From: Alison Driver [REDACTED]
Sent: 04 May 2017 11:39
To: Anita Gardner
Subject: Re: A/53/17/PO & A/105/16/PL & A/173/16/PL - The Cottrells, Angmering

There is a current application A/64/17/DOC which includes details in respect of condition 5 of A/105/16 - construction site set up. It is awaiting determination. County Highways comments have been received today and can be viewed on the council's website under reference AB/64/17/DOC. I will be advising the agent for the application that additional information is required and that they should not commence development until the condition is discharged.

Site Works Plan @ 1:100

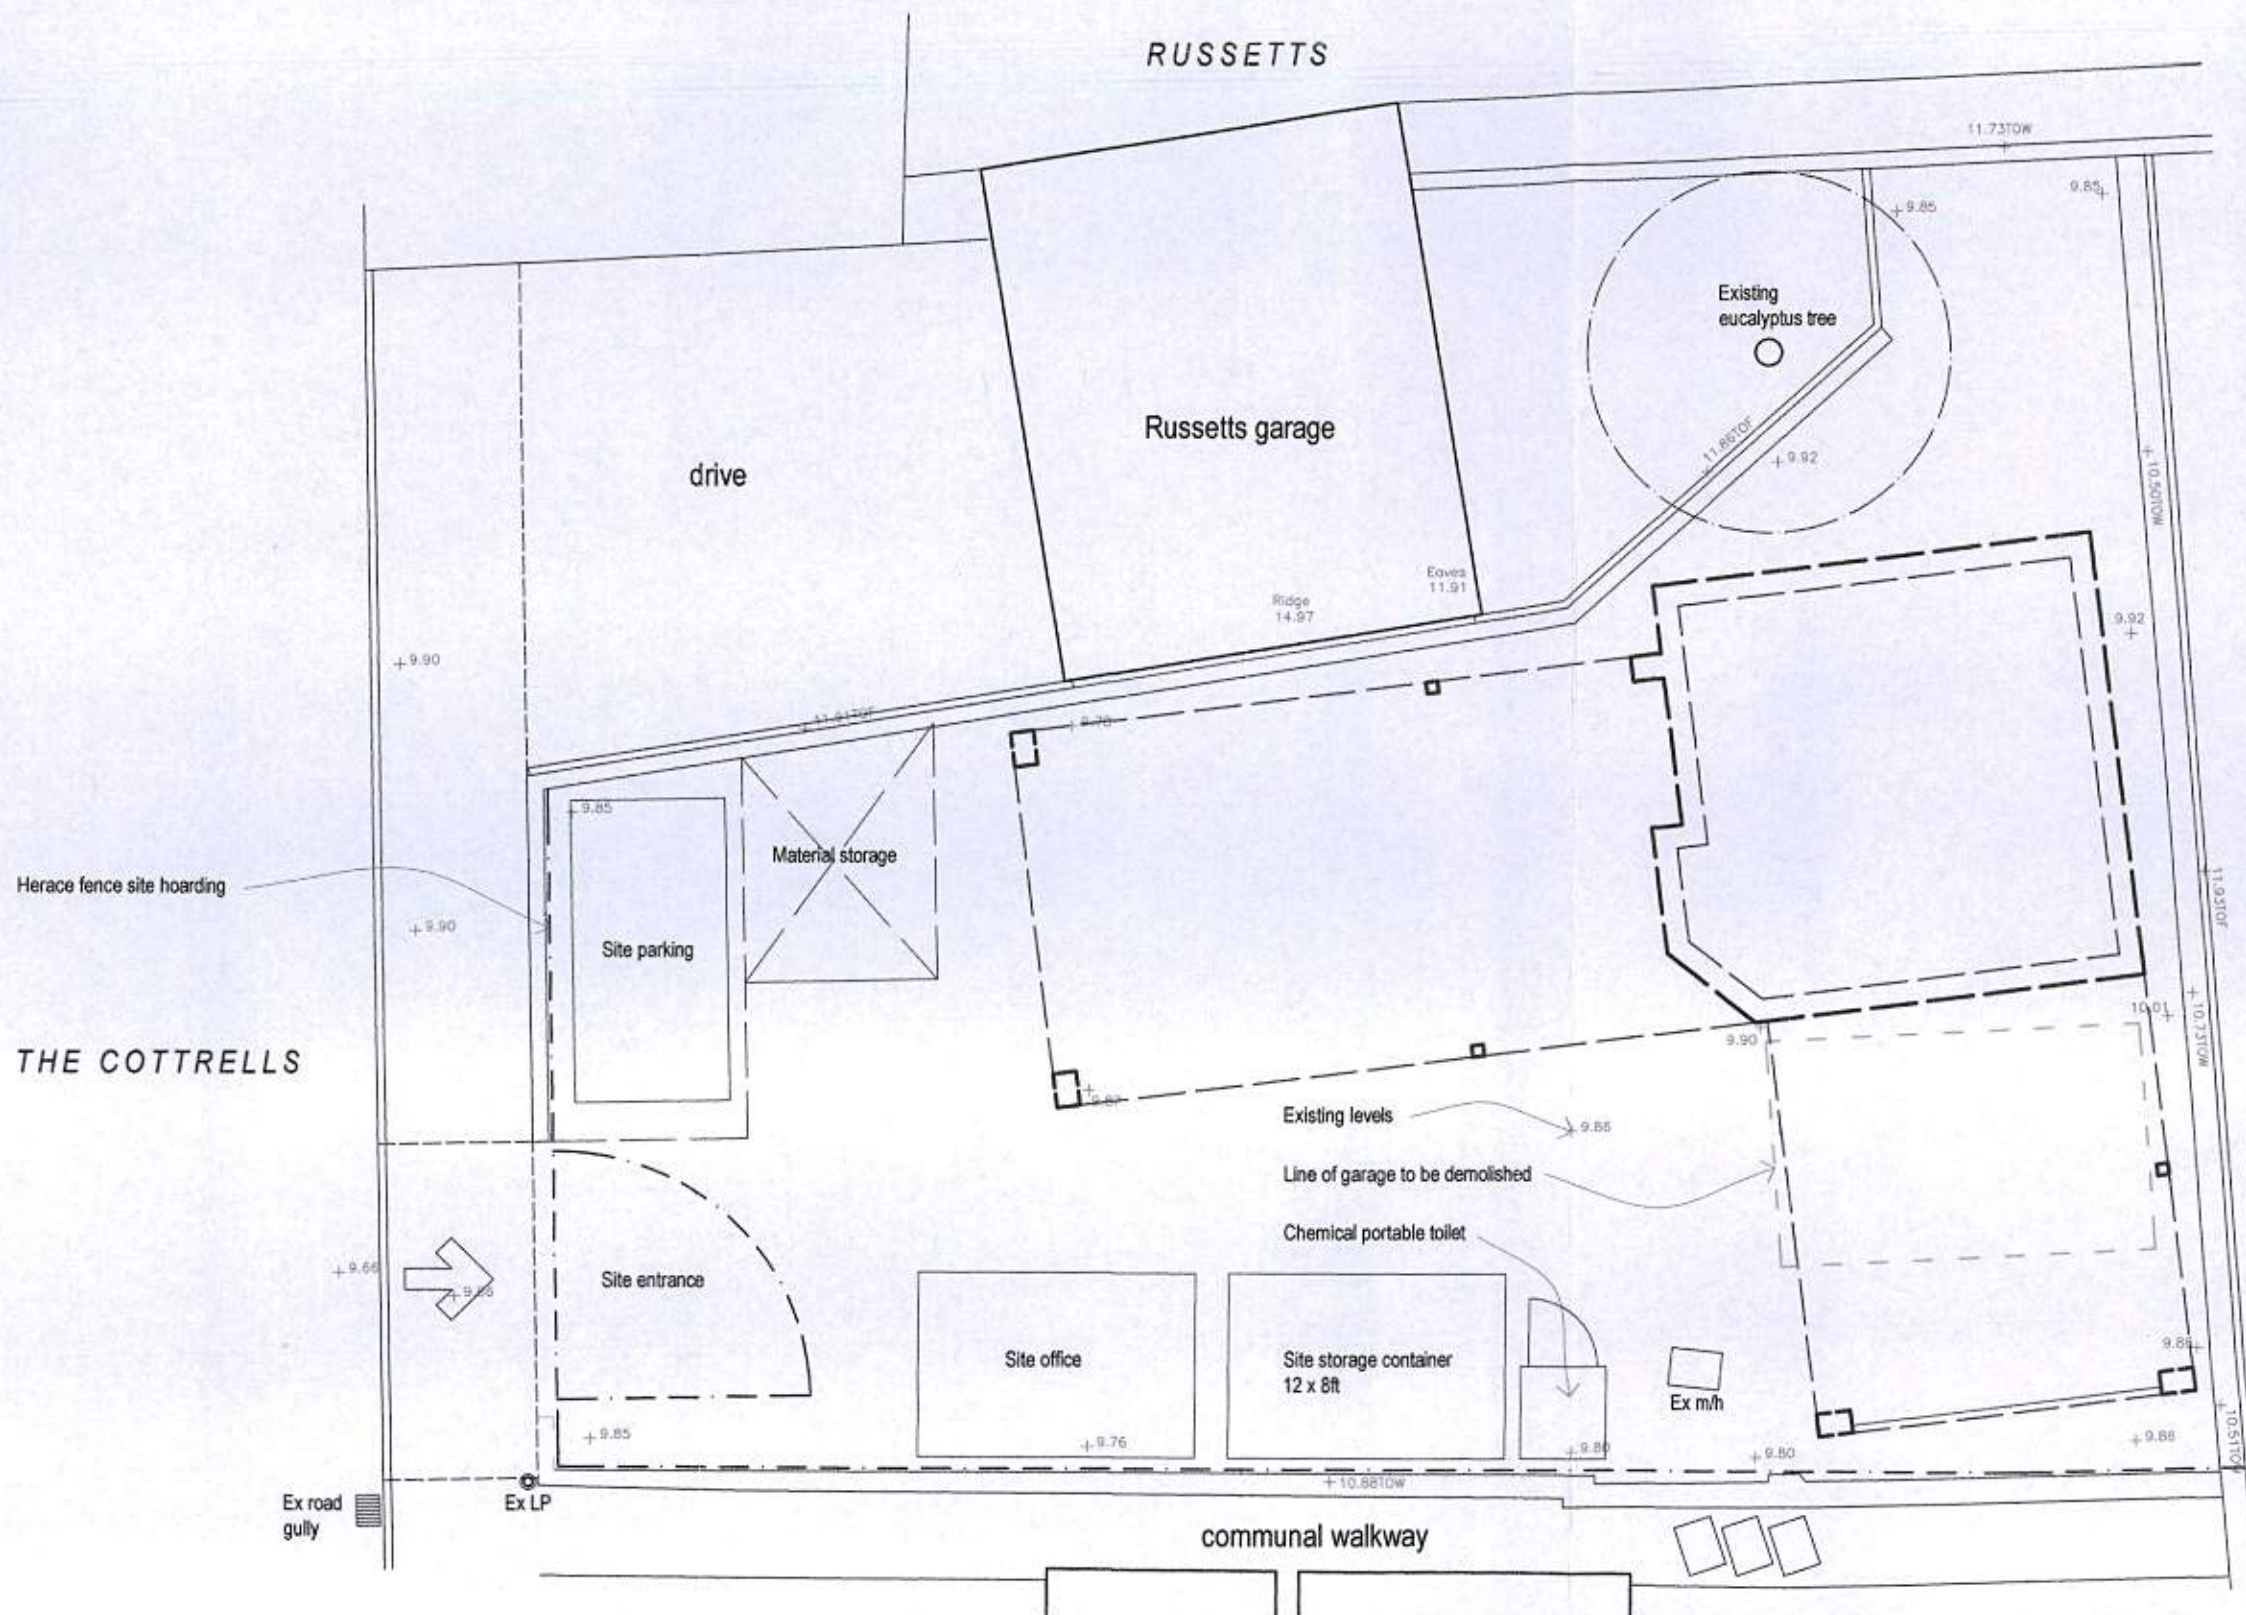
I see from the site plan on application A/64/17/DOC there is only parking for one vehicle on the site, I feel this is unrealistic when there are multiple trades working on the project.
